7000 Acres

Summary of Oral Submissions – ISH 3 5 December 2023

Cottam Solar Project

Battery Energy Storage System (BESS) Safety Concerns

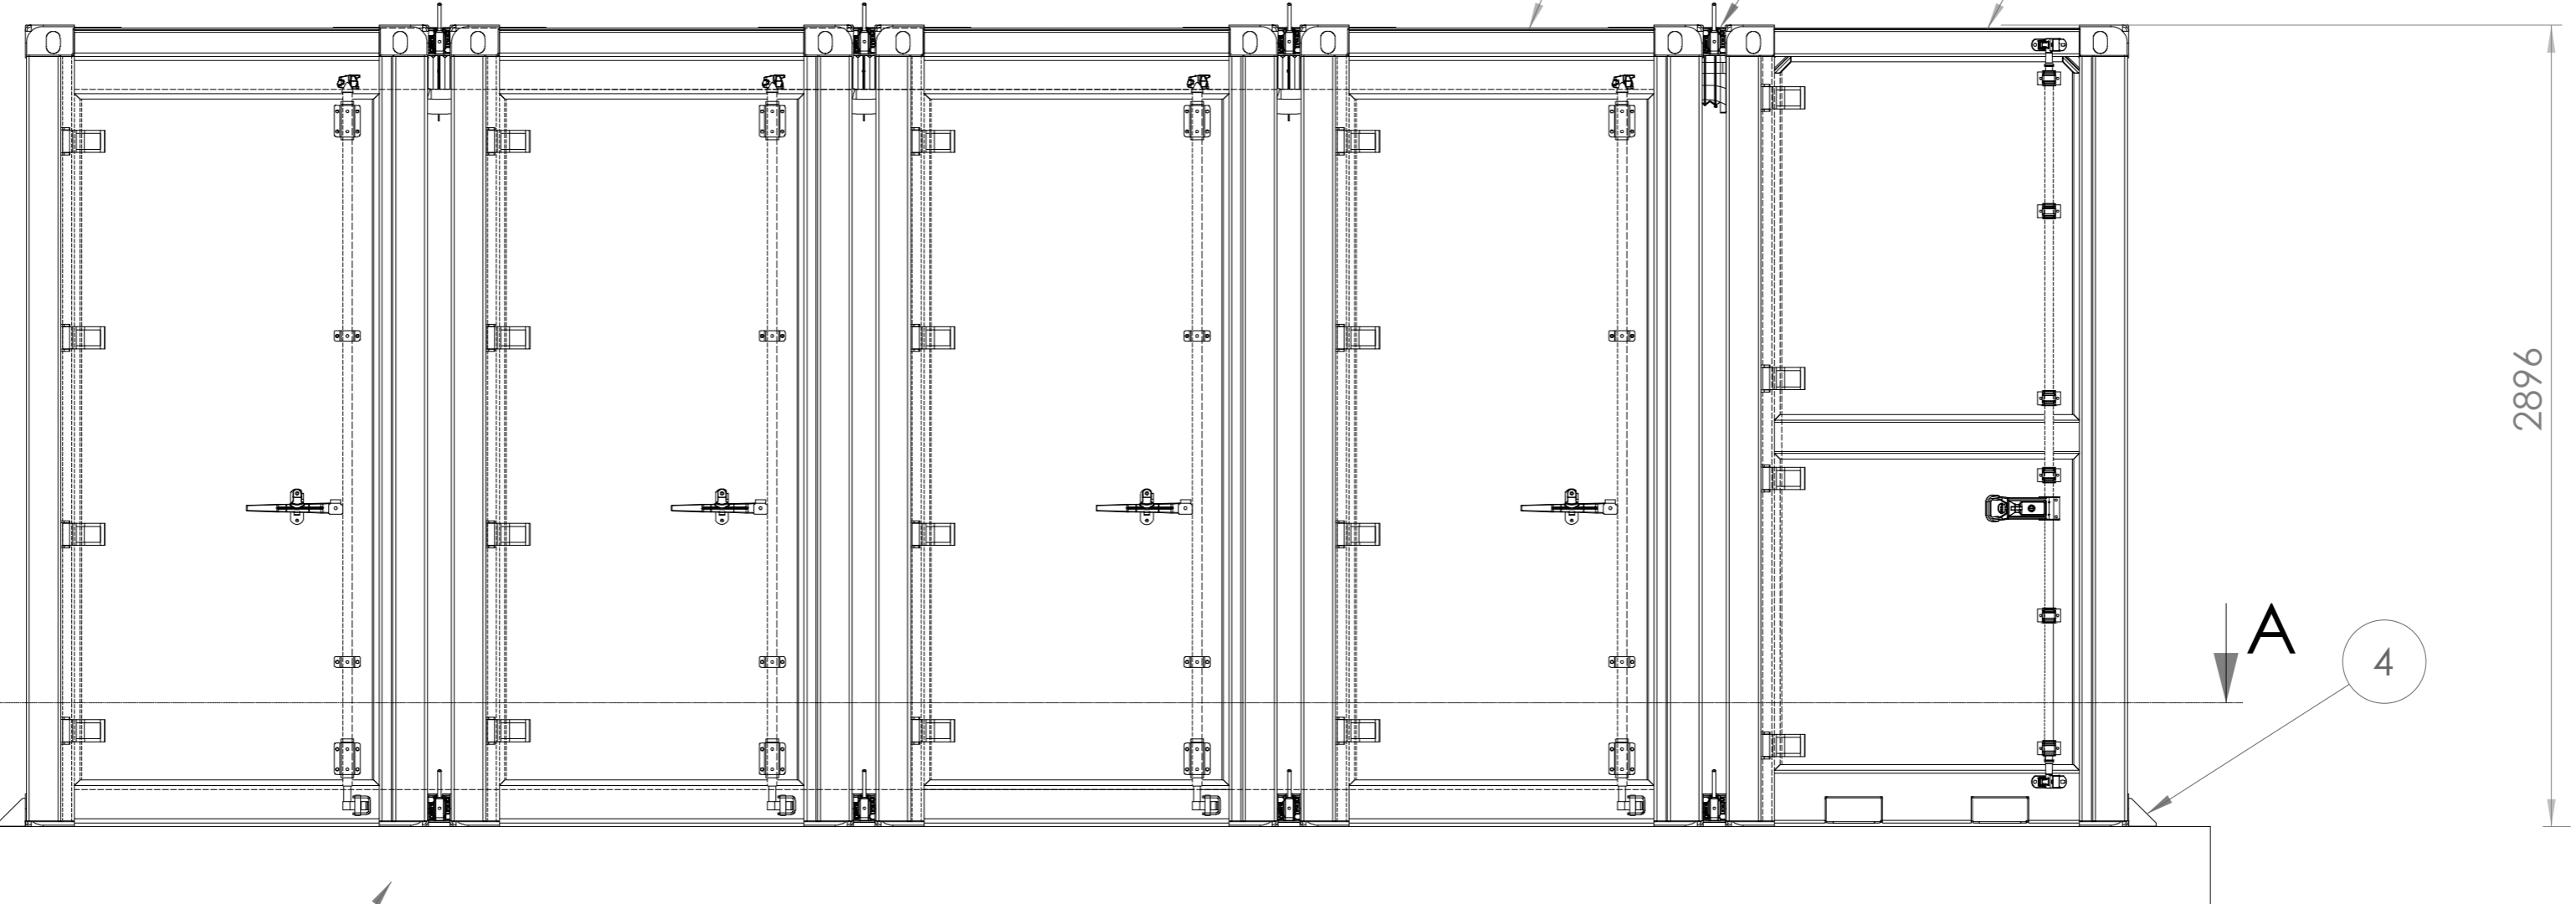
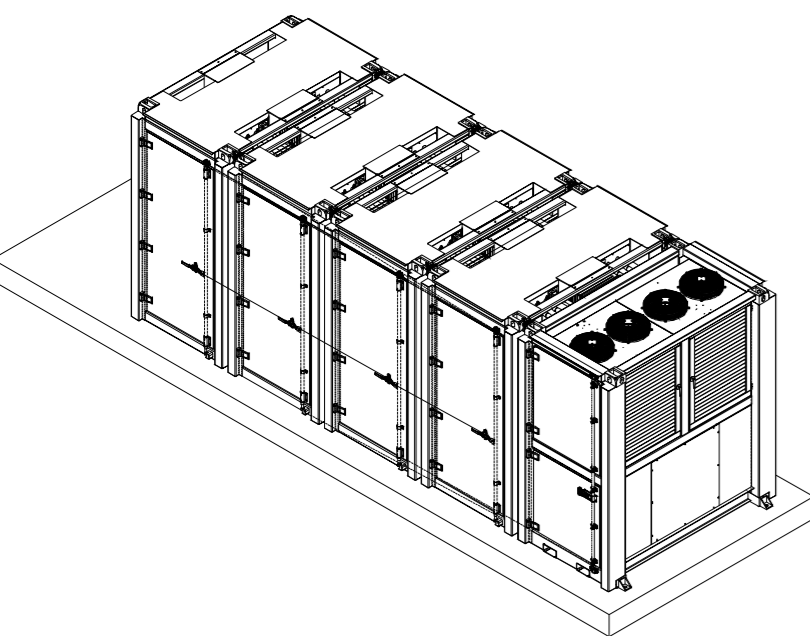
7000Acres has major concerns over siting a 500MWh (uncapped) BESS in a rural location that is without access to substantial volumes of cooling water. Evidence from previous accidents, including to a BESS in Liverpool, shows that a BESS thermal runaway is a sustained event, usually lasting for many hours, and requires substantial volumes of water to cool the facility. The dDCO Work No 2 B and 3 B show modules closely spaced or joined. The National Fire Chief Council recommends a distance of 6m between battery modules <https://nfcc.org.uk/wp-content/uploads/2023/10/Grid-Scale-Battery-Energy-Storage-System-planning-Guidance-for-FRS.pdf> :

As the Applicant has not provided any evidence, and is applying a Rochdale Envelope to the scheme, a reasonable worst case assessment (Advice Notice Nine) should be applied, and so the spacing distance of 6m must be applied.

At time 01:42:24:16 the Applicants battery specialist (Mr Gregory) conceded that he had not been involved in the design of the BESS (shown in Work No 2B and 3B) and that it was an indicative plan.

The current BESS design does not appear to contain sufficient bunding and storage capacity for large volumes of polluted fire water. This requirement should be secured in the dDCO.
